Application for a non-material amendment following a grant of planning permission.

Number	6
Suffix	
Property name	
Address line 1	Moor Park Road
Address line 2	
Address line 3	
Town/city	Northwood
Postcode	HA6 2DN

32415/APP/2020/2984

2020 - Approved Plans - Existing & Proposed Side Elevations (KS/2020/05)
2007 - Approved Plans - Existing & Proposed Side Elevations (RP/06/07/A)

DRG. No. KS/2020/05

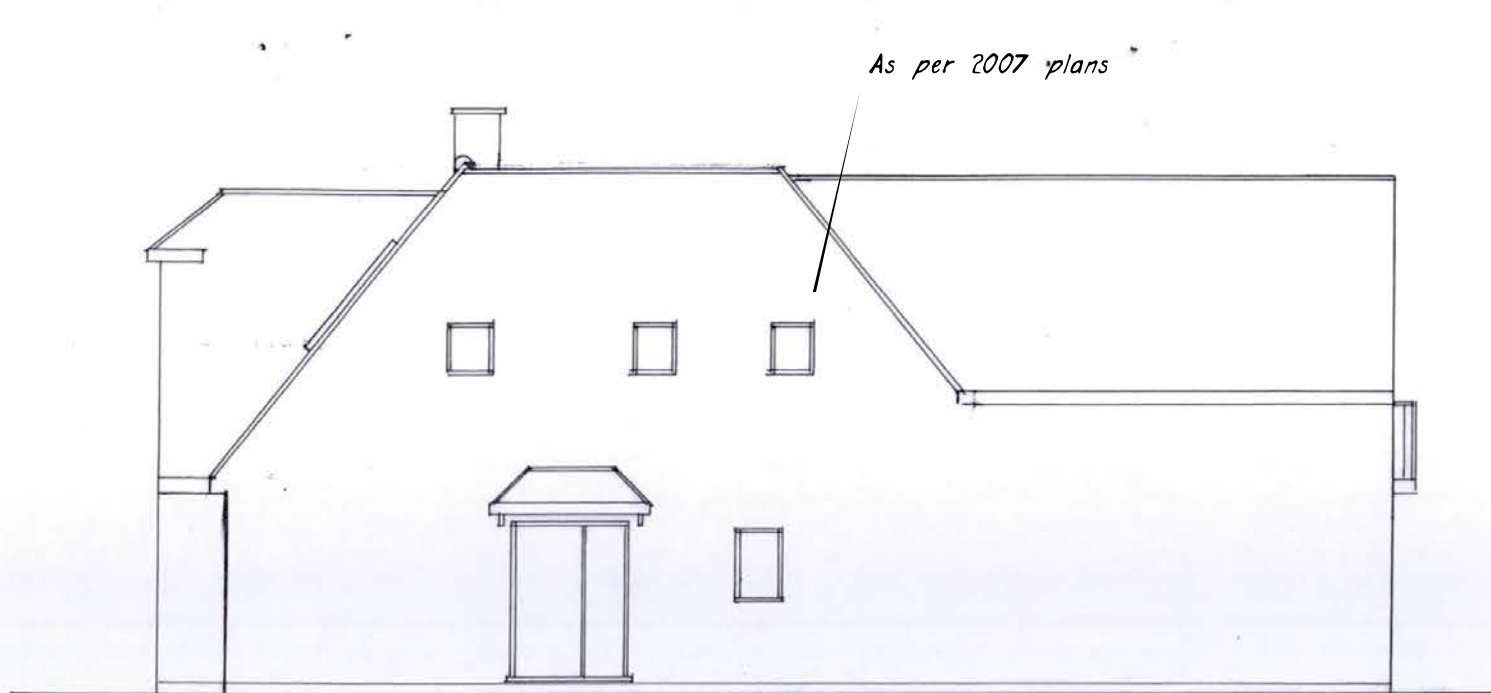
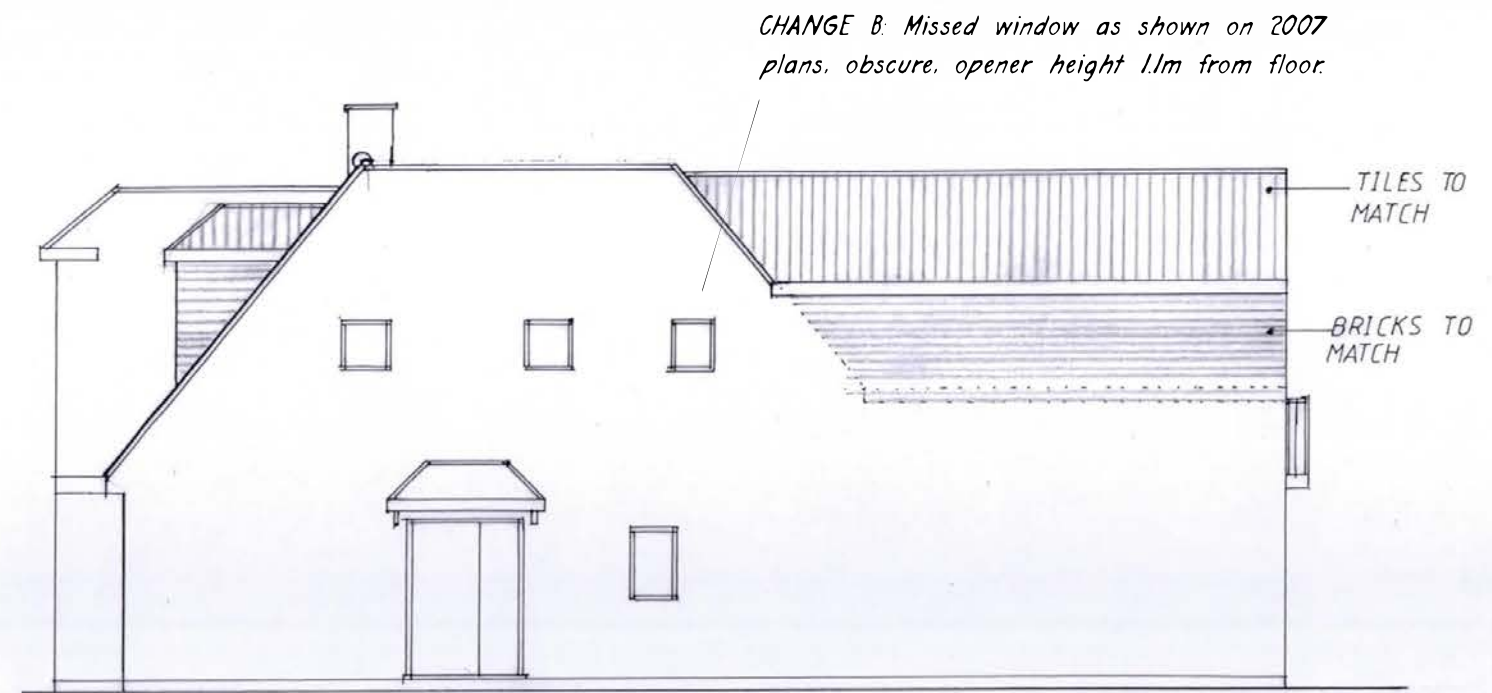
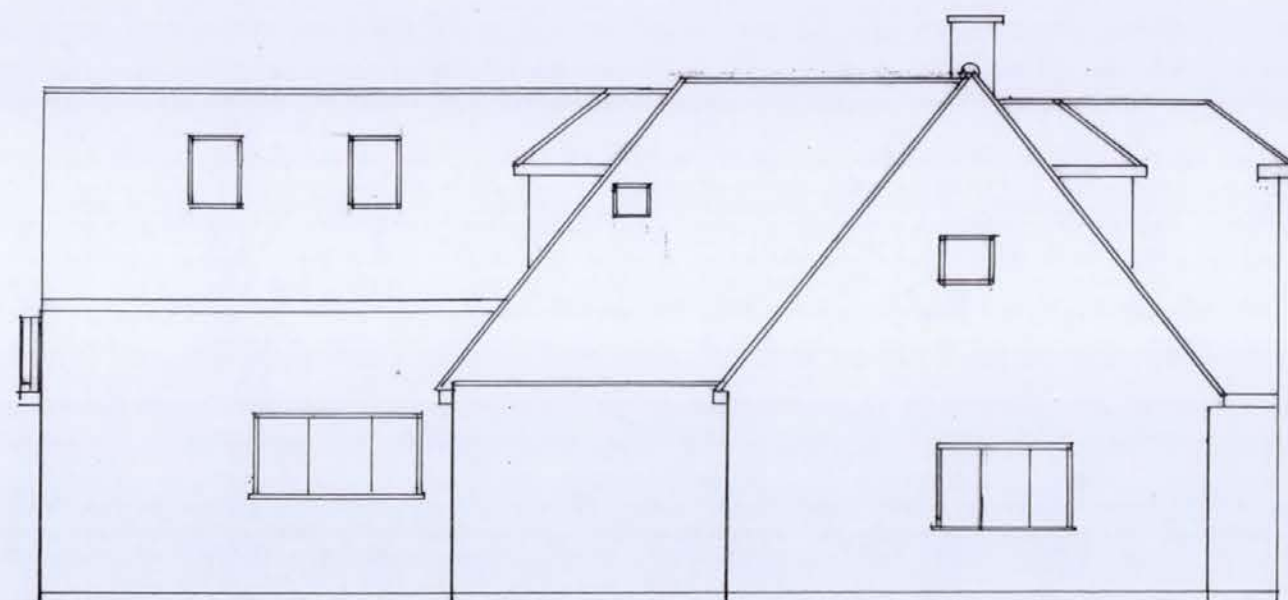
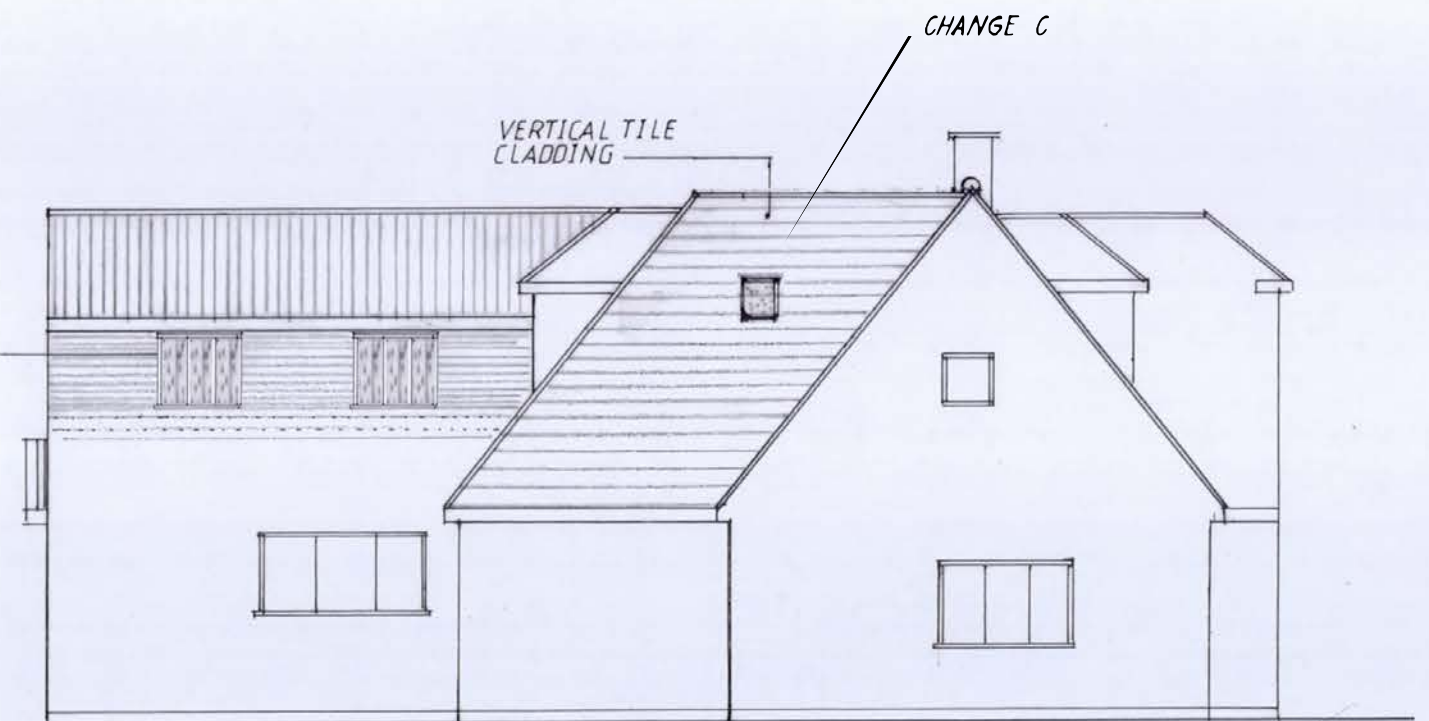
Change A. It was established that the windows located on the side elevation of the first-floor side extension are larger than shown on the approved plan (drawing number KS/2020/05) and as such a breach of planning condition 2 has occurred.

Change B. It was also established that a new window has been inserted into the (eastern) side elevation of the original dwelling house at first floor. The window is obscure glazed and opening below 1.7 metres from floor level (the opening is at 1.1m).

Not raised by planning officer but for completeness, Change C are minor changes to the small gable window to adequately allow for light, ventilation, access to opener to meet condition of openers below 1.8 facing 8 Moor Park Rd.

Action Taken: Drawings updated to reflect the installed windows - Change A.

Action Taken: Drawings are updated to reflect the installed window - Change B.

1. The windows are fixed glazing at bottom with only a top opener (60cmx80cm vs 60cmx60cm), to allow for an opening above 1.8m whilst allowing enough light.

2. The position of the window has been increased slightly to respect the 1.8m minimum

Summary: The window is obscure with an opening above 1.8m, action plans updated
